# ENG-SKP22004-R4-MDDPPDR.pdf Markup Summary

1 (1)		
	<div><div>COLL</div><div>5</div></div> <div><b>Subject:</b> Text Box <b>Page Index:</b> 1 <b>Date:</b> 1/19/2023 9:34:26 AM <b>Author:</b> dsdrice <b>Color:</b>  <b>Layer:</b> <b>Space:</b> <b>Page Label:</b> 1</div>	Refer to comments also made on SP-22-004. This report is acceptable as a MDDP placeholder if necessary but only if needed prior to recording a plat.

SKP 22-004

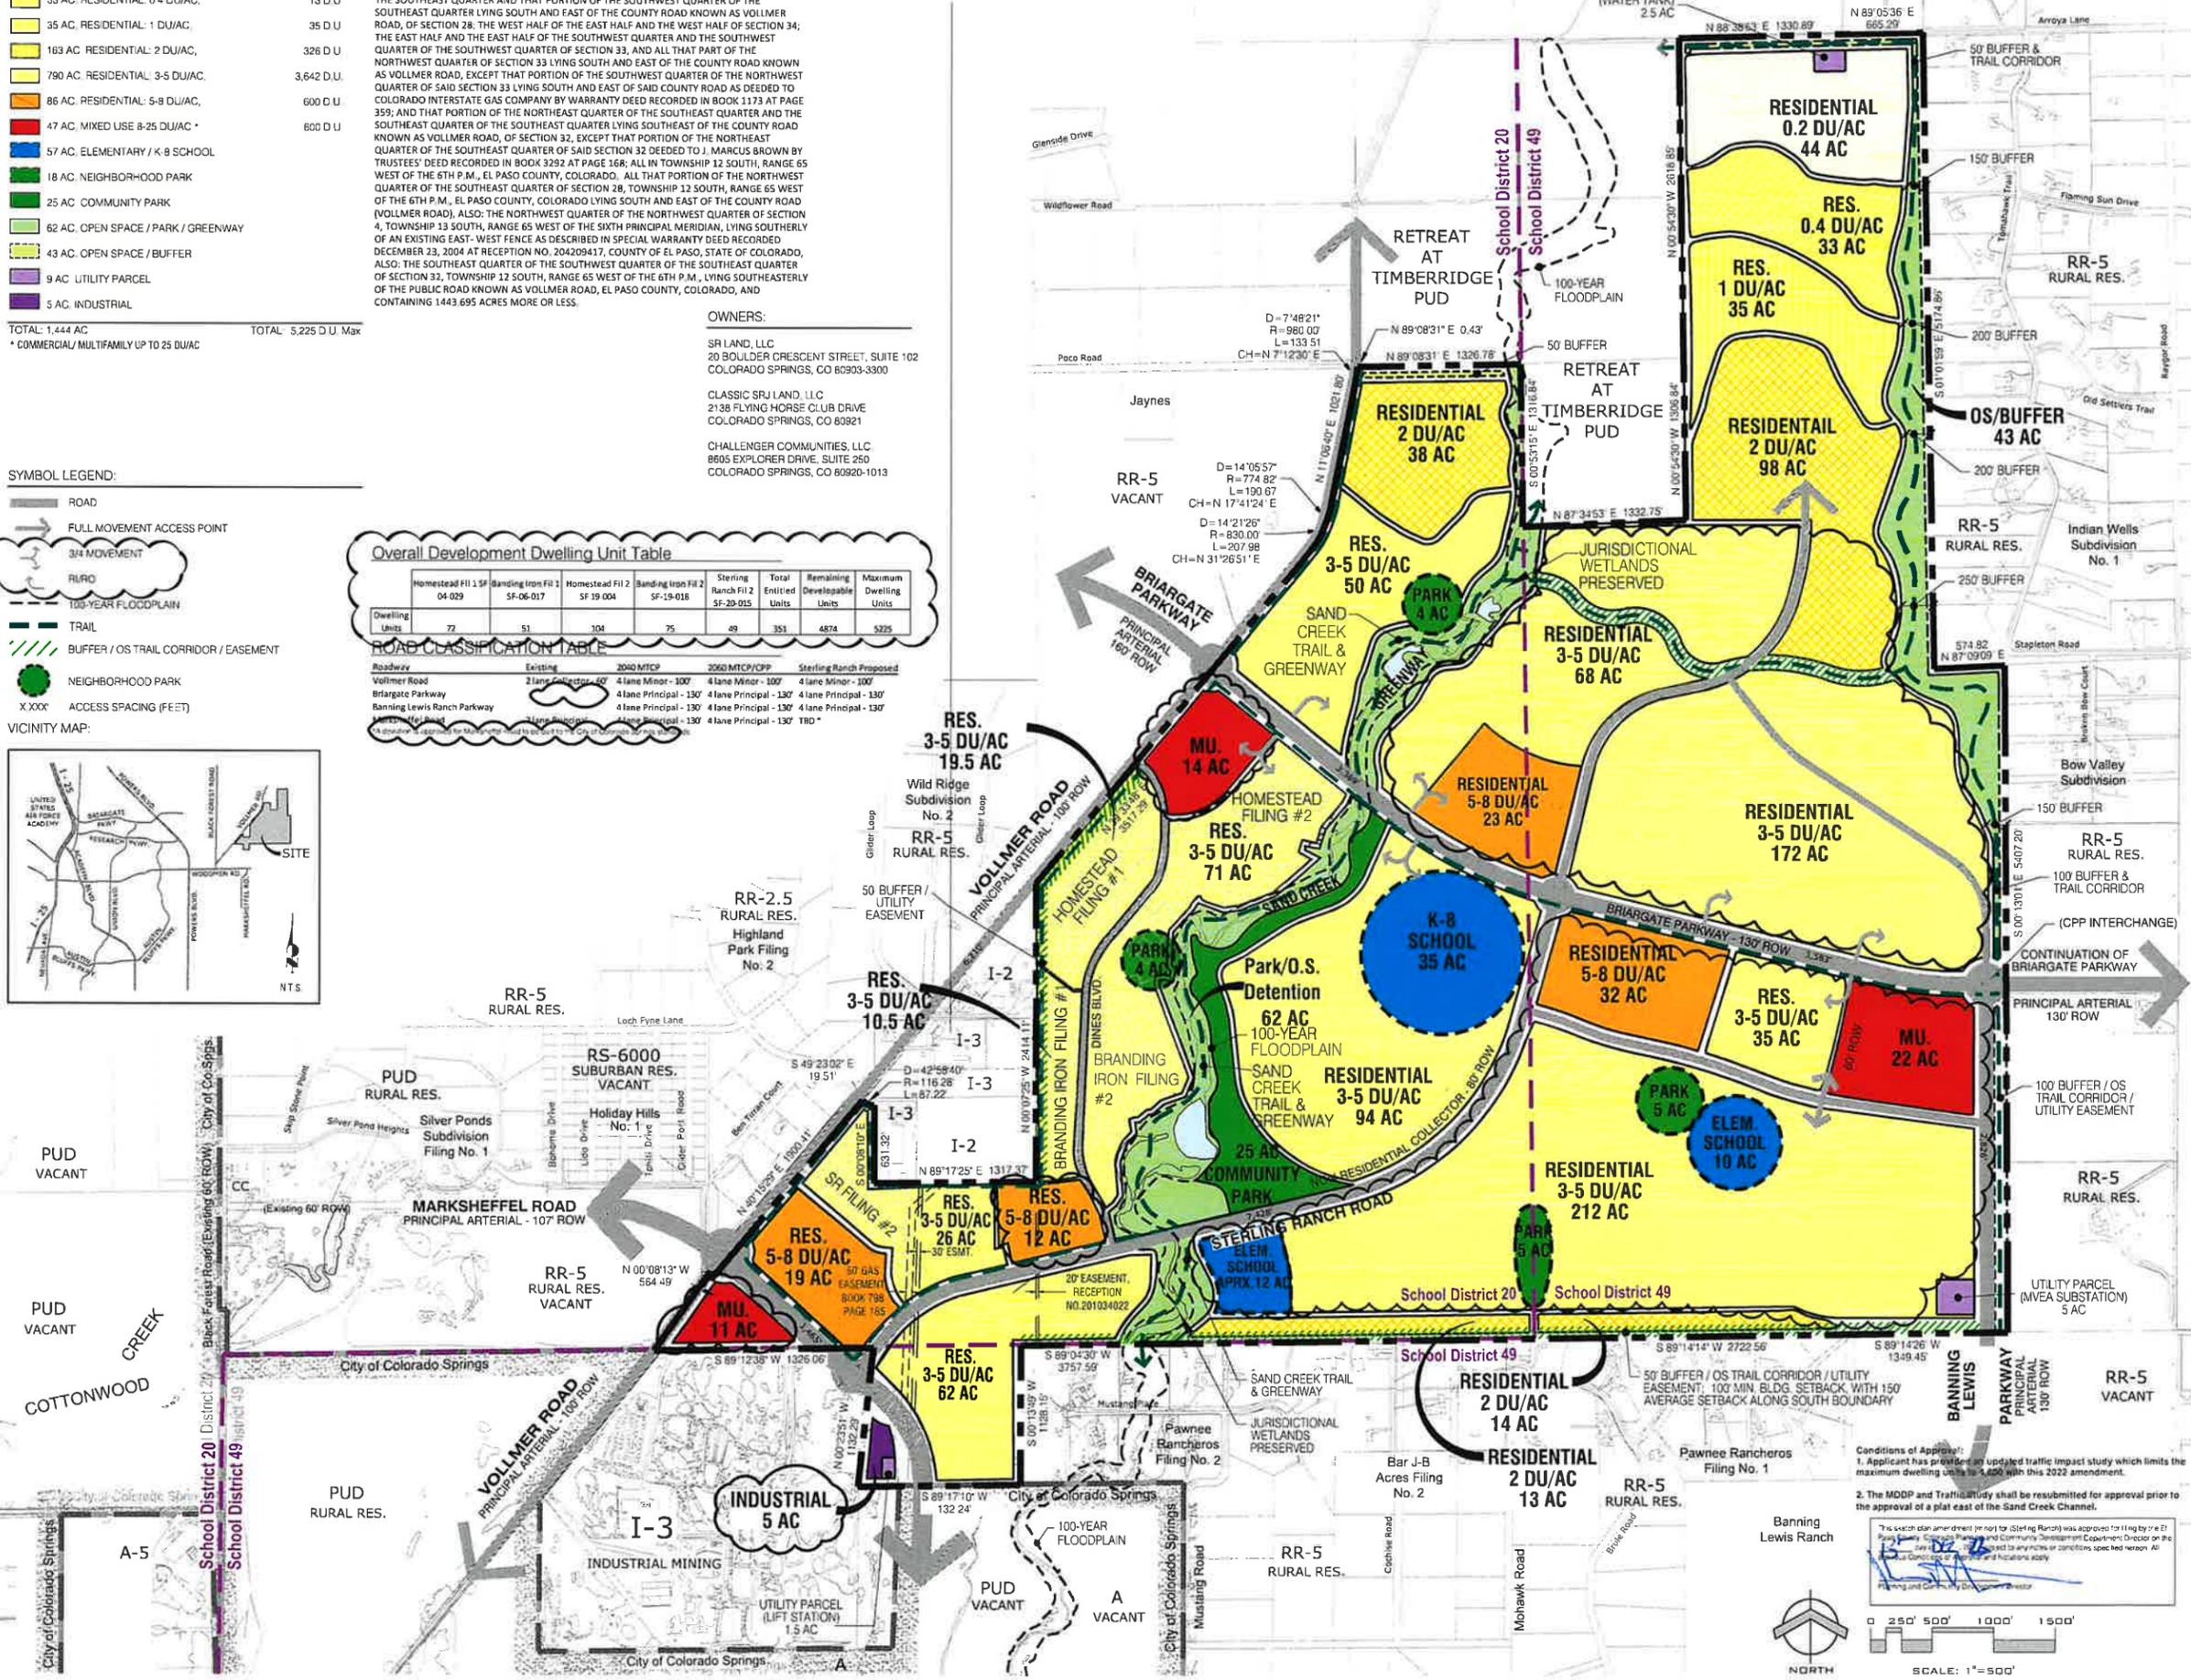
100 (2)		
	<div><div></div><div></div></div> <div><b>Subject:</b> <b>Page Index:</b> 100 <b>Date:</b> 1/18/2023 2:22:20 PM <b>Author:</b> dsdrice <b>Color:</b>  <b>Layer:</b> <b>Space:</b> <b>Page Label:</b> [1] Model</div>	
	<div><div></div><div></div></div> <div><b>Subject:</b> Callout <b>Page Index:</b> 100 <b>Date:</b> 1/19/2023 9:42:57 AM <b>Author:</b> dsdrice <b>Color:</b>  <b>Layer:</b> <b>Space:</b> <b>Page Label:</b> [1] Model</div>	Update this area
